## STAFF REPORT SASSE RIDGE PRELIMINARY PLAT

TO: Kittitas County Hearing Examiner  
FROM: Kittitas County Community Development Services Staff  
RE: Sasse Ridge Preliminary Plat (LP-11-00002)  
DATE: January 10, 2013

SASSE RIDGE PLAT

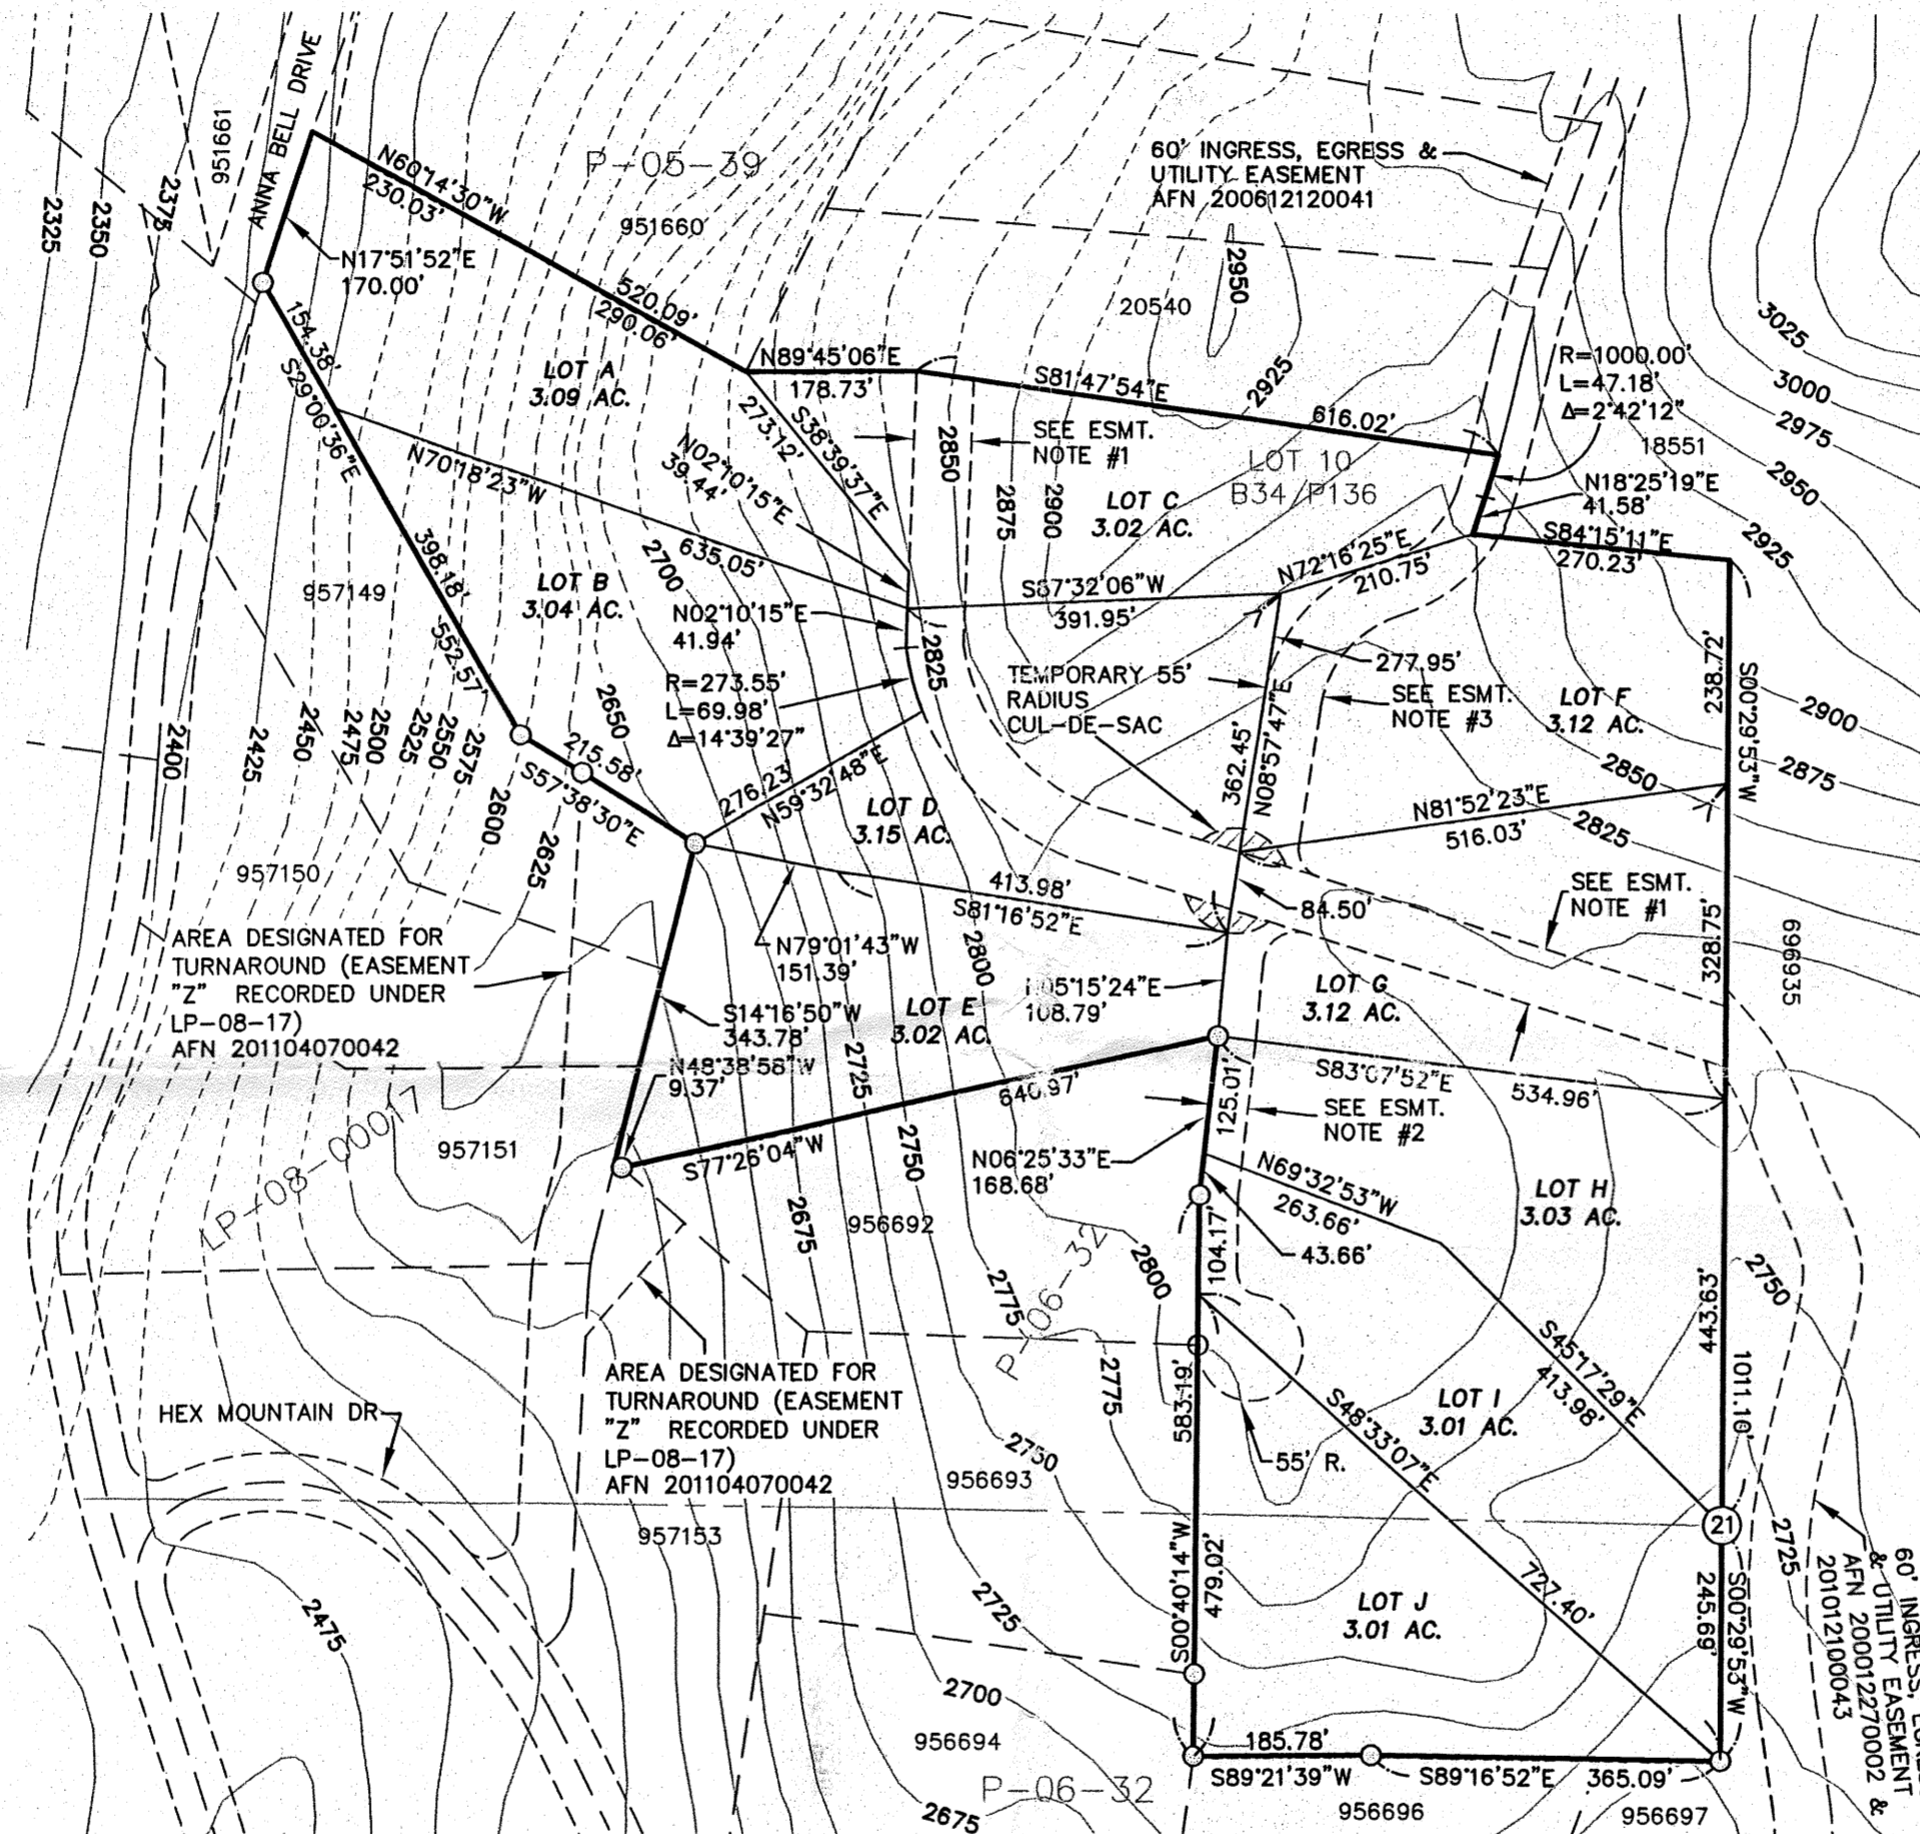
This proposal is not consistent with the Kittitas County Zoning Code 17.30.055 Yard Requirements – Zones Adjacent to Commercial Forest Zone. The preliminary plat map does not show the required 200-foot buffer for properties bordering or adjacent to the commercial forest zone. The minimum lot size is 3 acres. The lots in this proposal range in size from 3.01 ac. to 3.12 ac.

8. As KCC 17.30.055 requires, the final plat shall show a 200-foot buffer on all properties bordering or adjacent to properties zoned commercial forest.
